**Consultation Response from KC,
Lead Local Flood Authority****2025/91211 east of, Mill Lane, and Heaton Grange, Hanging Heaton, Batley, WF17 6EN****Discharge of details reserved by conditions 6 (road specification), 7 (retaining walls), 8 (highway structures), 10 (noise assessment report), 17 (drainage strategy), 18 (surface water discharge), and 19 (storm events) on outline permission 2020/93777 for erection of residential development****Date Responded: 02/06/2025.****Responding Officer: Martin Stephenson****Responding Ref: 1****Previous response by the LLFA**

Discharge of Drainage Conditions

Documents reviewed by the LLFA:

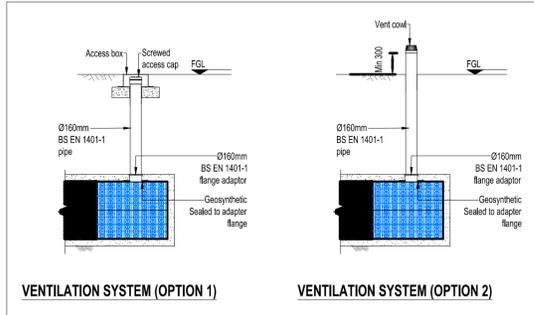
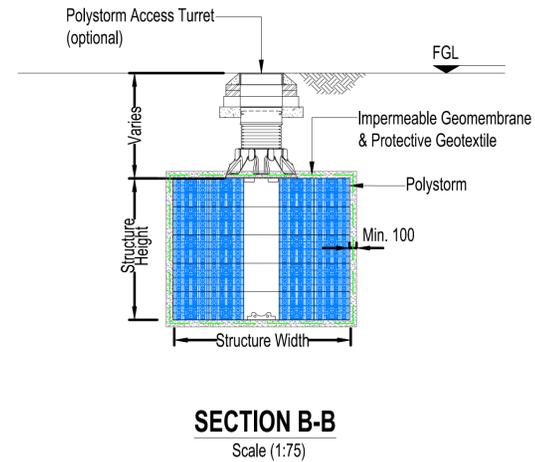
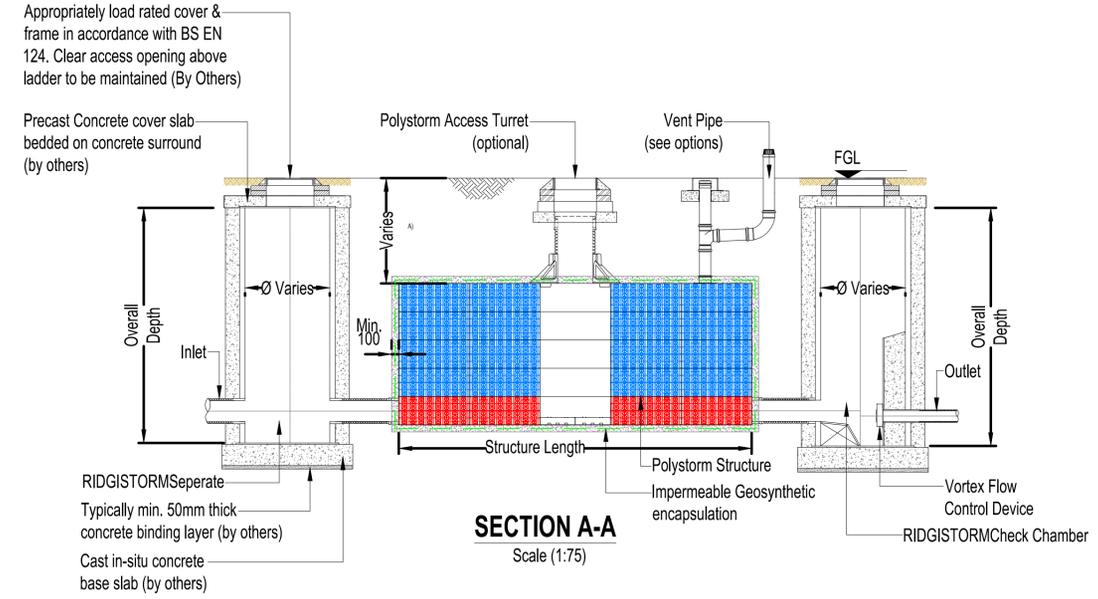
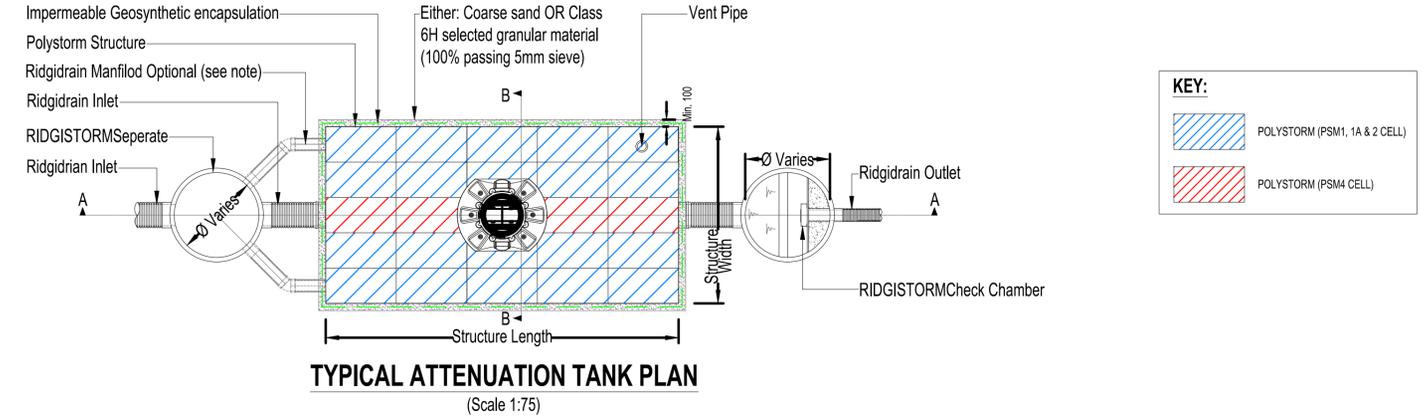
The proposed drainage as detailed on the Proposed Drainage GA drawing is generally acceptable to the LLFA; it is suggested, however that the silt trap MH upstream of the attenuation tank should be MH S10 rather than S14 (or both) as stated in the Drainage Strategy and detailed on the Typical Attenuation Tank Details drawing as this MH will be more easily accessible during desilting operations. Also, this MH should be clearly noted on the Proposed Drainage GA as a silt trap MH to ensure the Contractor installs the correct type. These suggested changes should be incorporated into the Construction drawings and the drawing does not need to be re-submitted to the LLFA. Therefore, the LLFA confirms that Condition 17 **can** be discharged.
